Molly McGuire  
Mercer Island Community Planning and Development Department  
RE: Clarifications on Building Permit 2207-019 SUB4  
June 28, 2023

I am writing in response to two letters submitted as Building Permit 2207-019 SUB4.

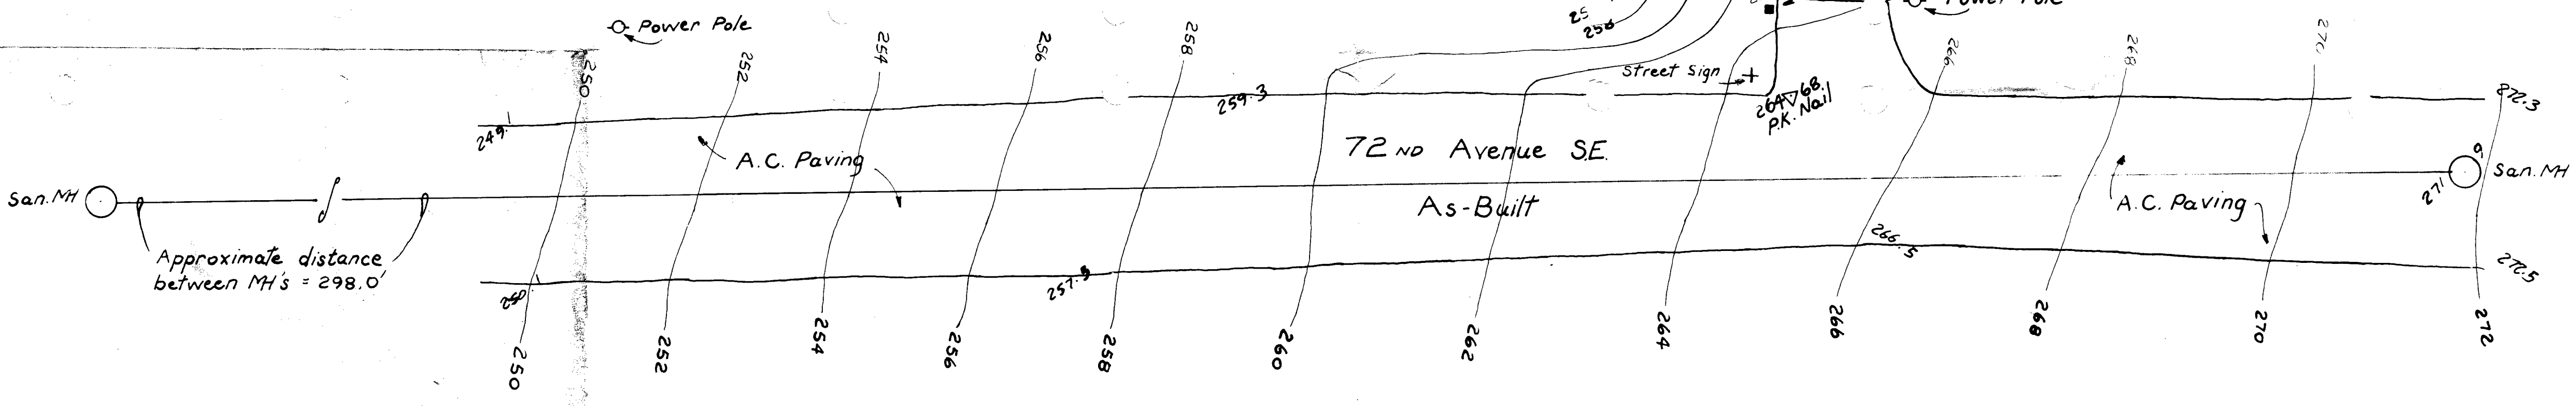
*"The D.R. Strong survey references a parcel located to the west of 72nd Avenue SE, but does not state exactly where, along 72nd Avenue, the site depicted is situated. The existing structure on the Strand lot is very old and was standing at the time of the D.R. Strong survey, but is not reflected on the sketch. "*

The D.R. Strong survey is from 7415 SE 35th Street, and was obtained from the Mercer Island GIS for 7145 SE 35th (link from GIS is [here](#), site plans with the address and matching contours is found [here](#)). The 6950 SE Maker structure is clearly shown in this survey and highlighted below. In fact, the SUB4 letter from Mr. Miller (Terrane Inc.) agrees that this survey closely matches the northern boundary of 6950.

AVERAGE BUILDING ELEVATION CALCS:

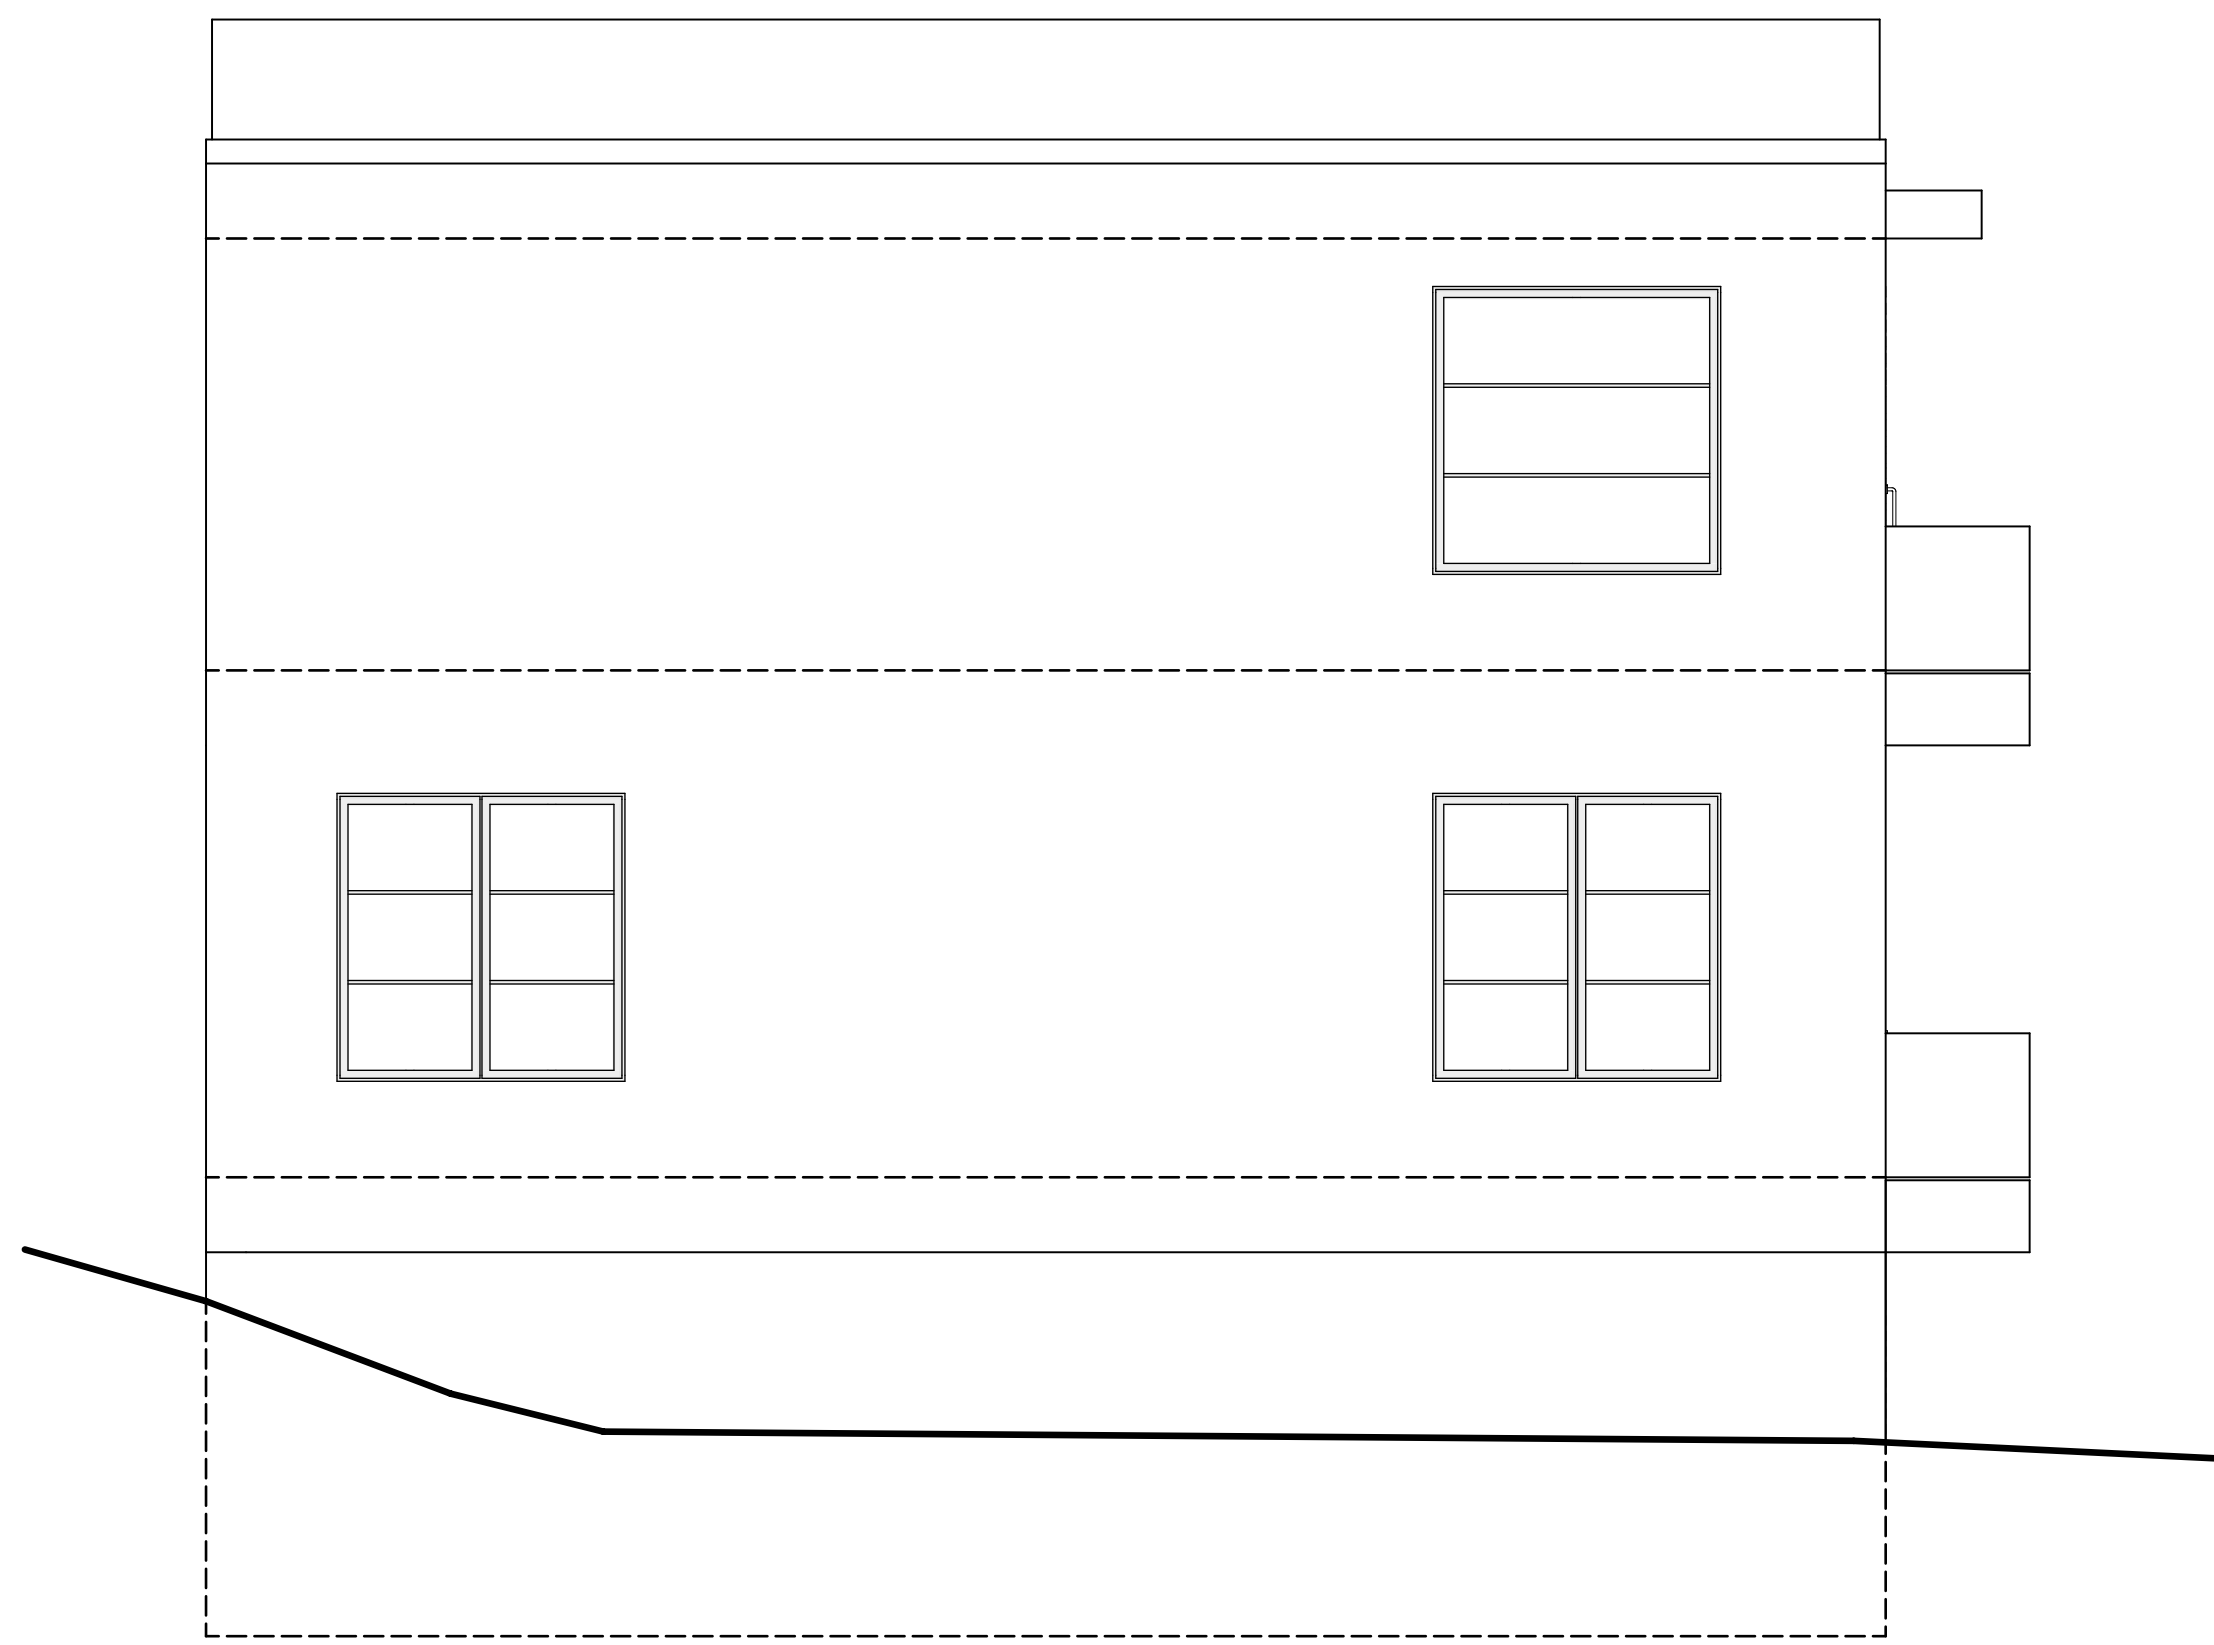
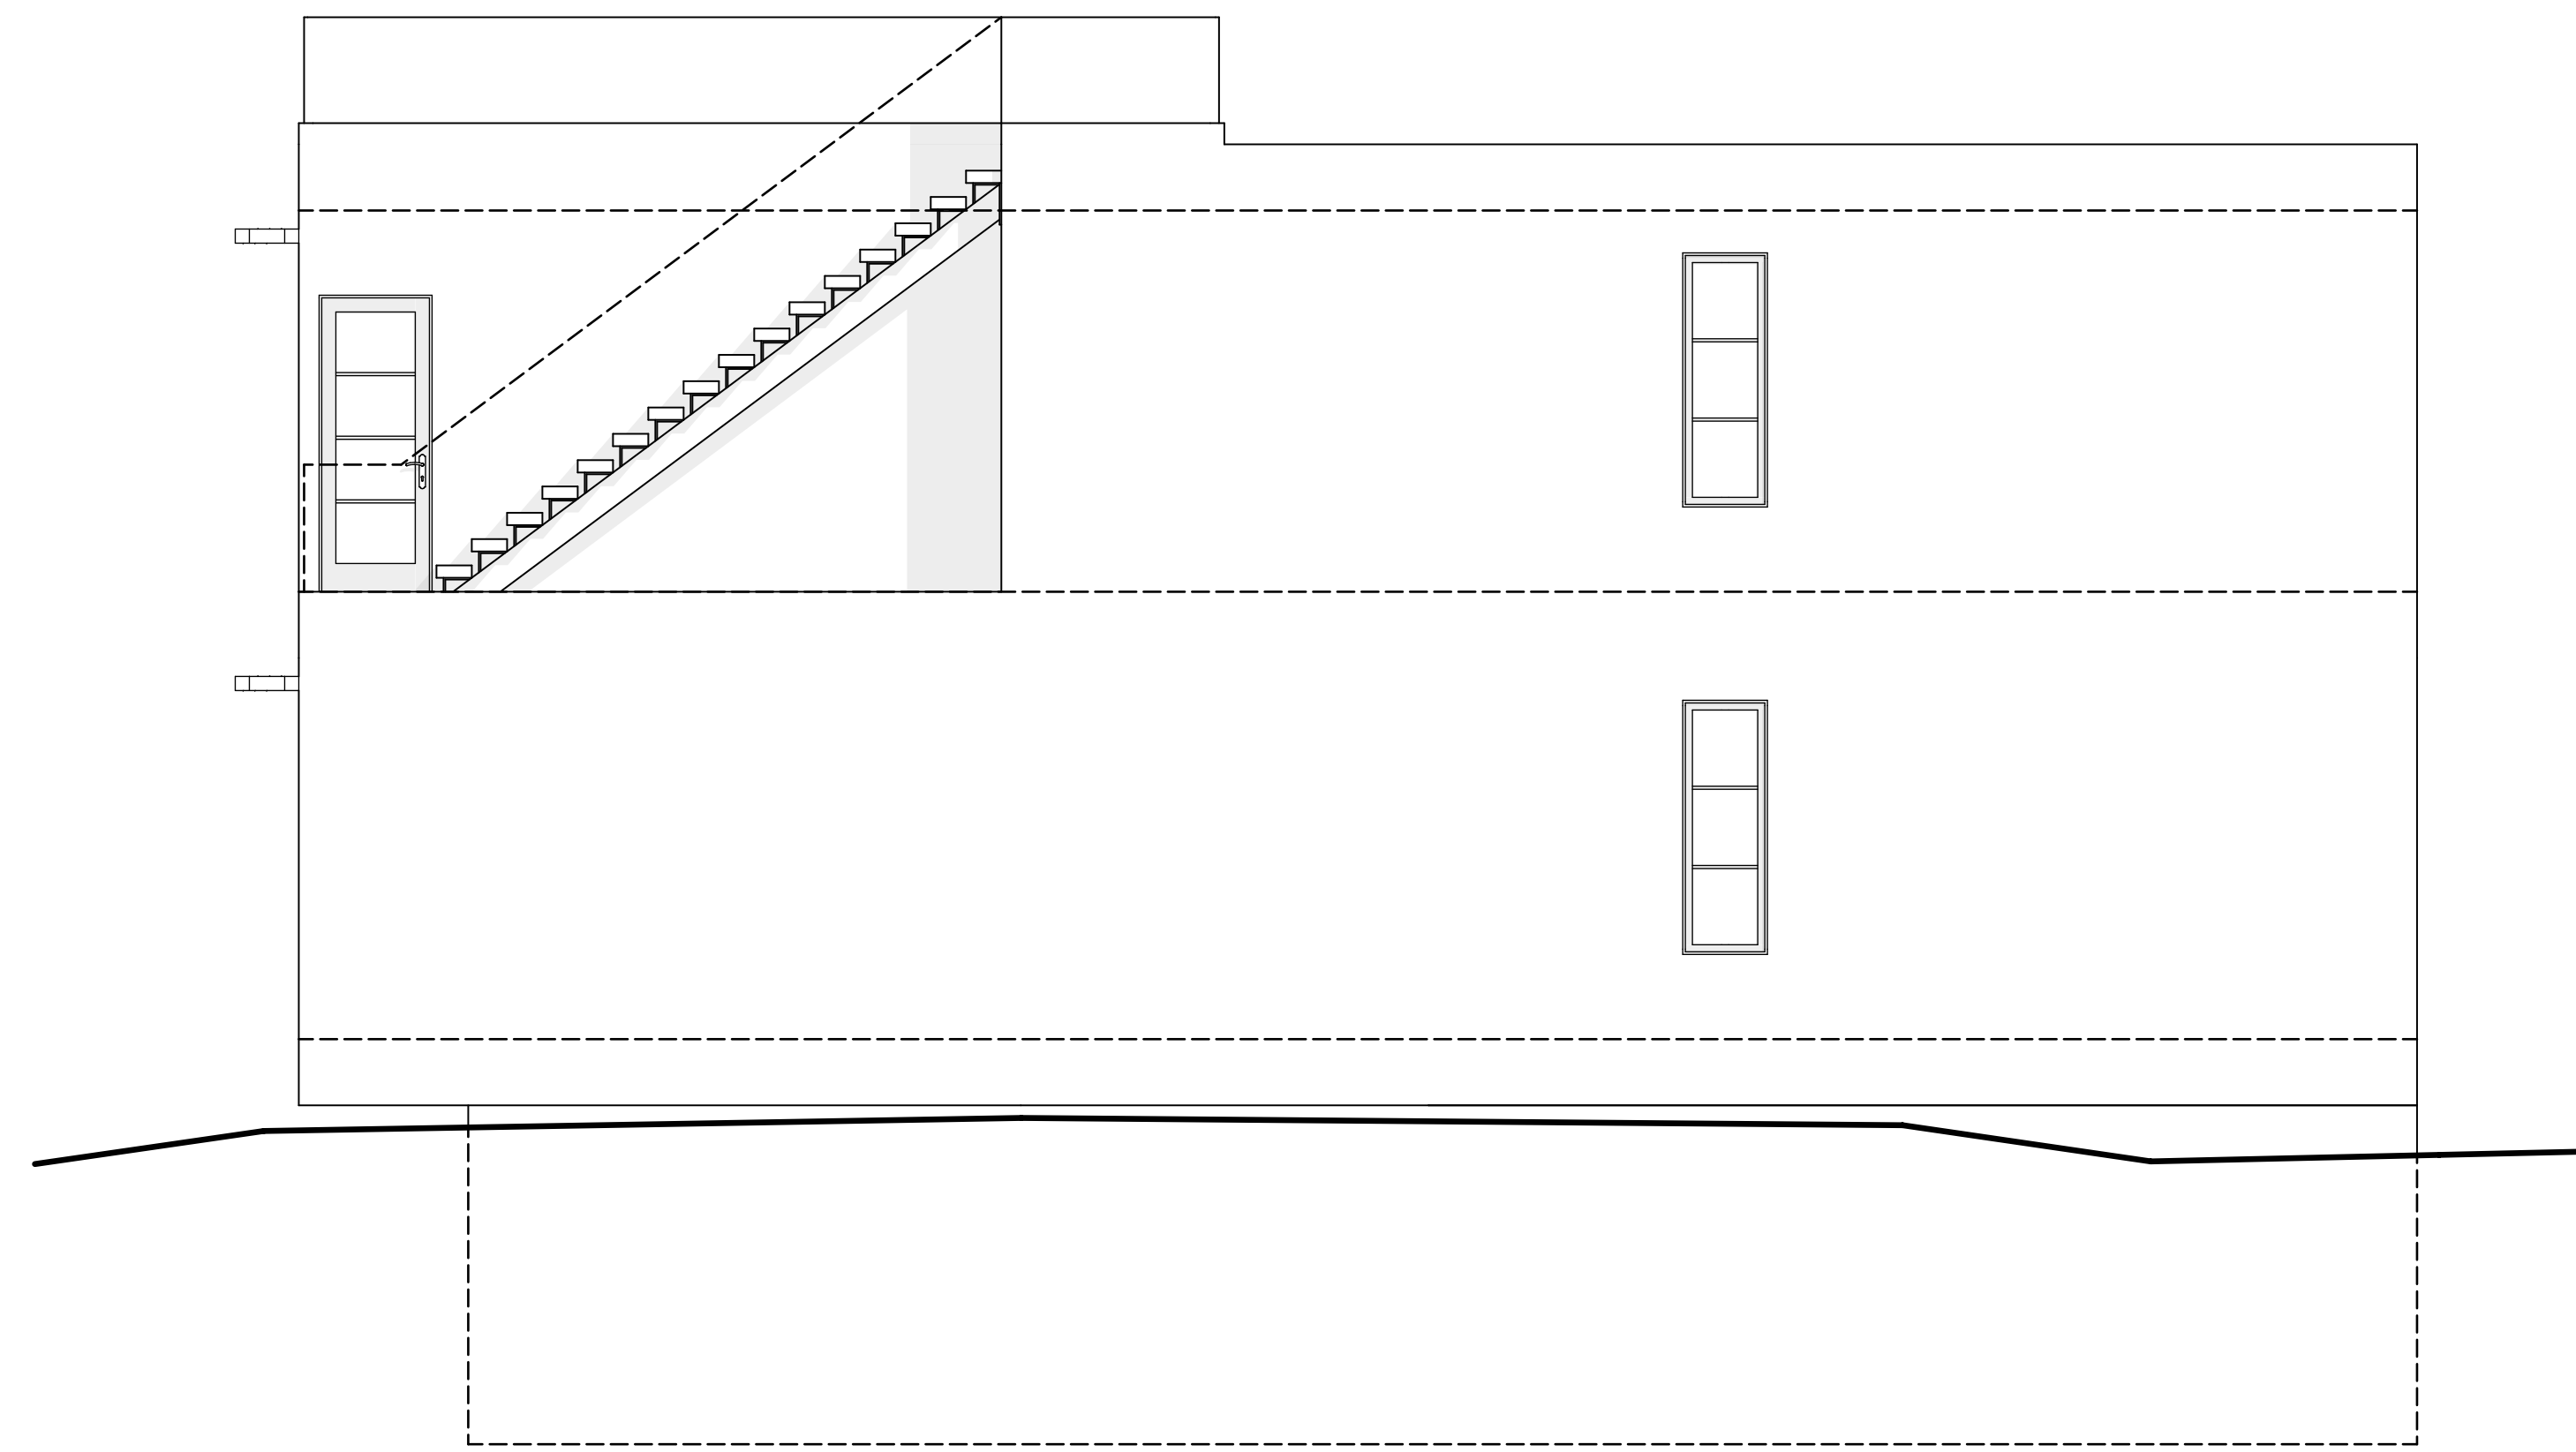
Finally, none of the submissions made to date have acknowledged that the northeast portion of the proposed structure sits on a walk-out basement slab at a grade of 228', shown below.
